From: Holly Myers
Sent: Tuesday, December 02, 2014 3:06 PM
To: Kaycee Hathaway
Cc: Joe Gilbert; Holly Duncan
Subject: BL-14-00022

In order to provide appropriate comments, we require the applicant provide specific details of the water system serving the two parcels.

BL 14-00022  
 Current line: 104636  
 Est of Douglas Curry

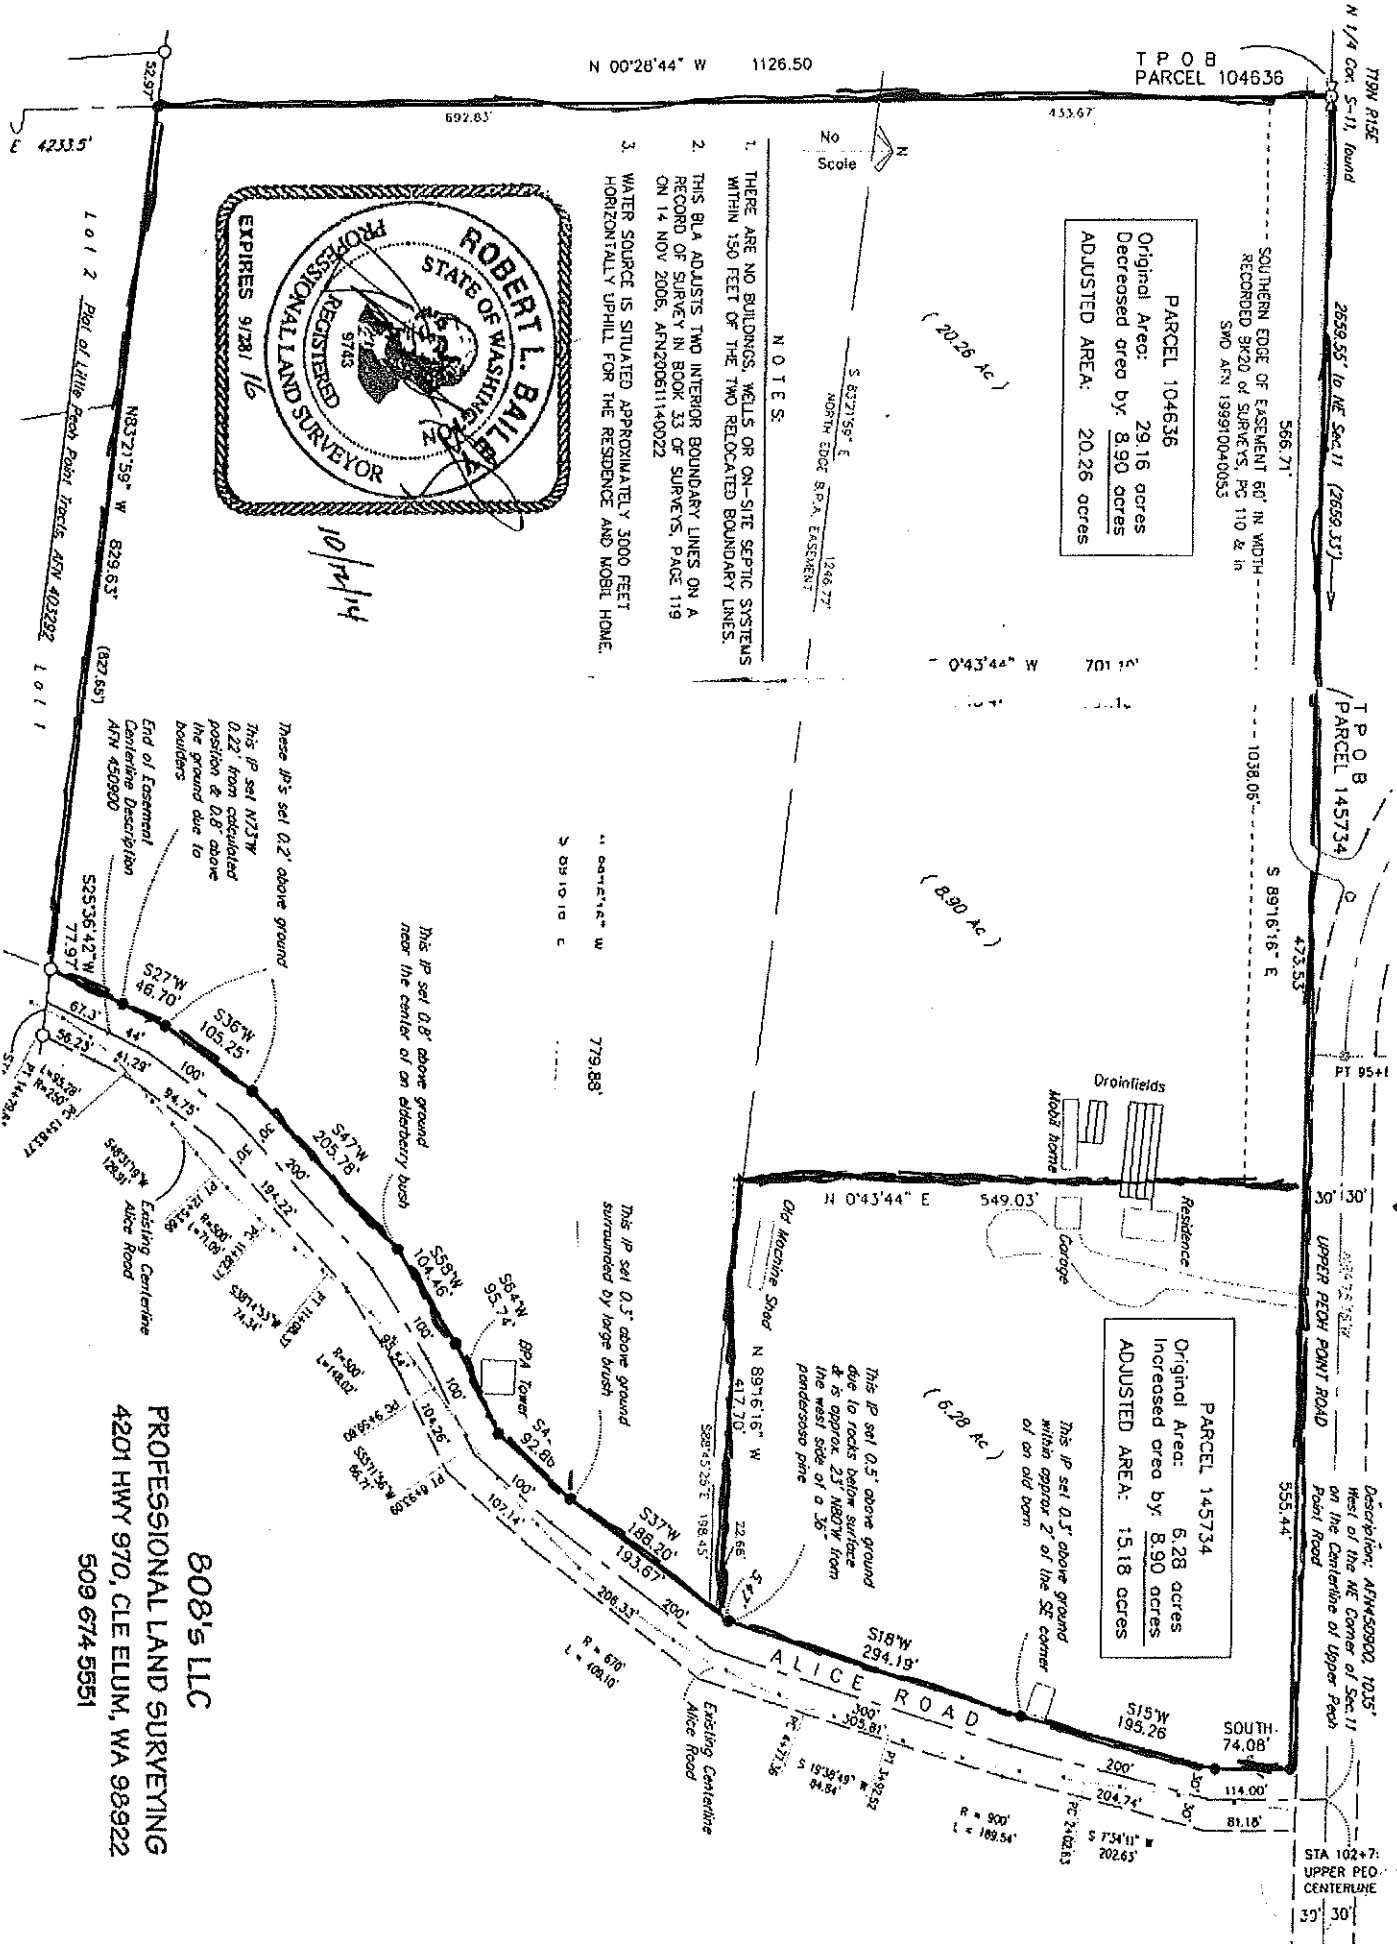
Joe is looking more closely at the concern over the drain field locations. It may be required that an easement agreement exist for future access to portions of the OSS.
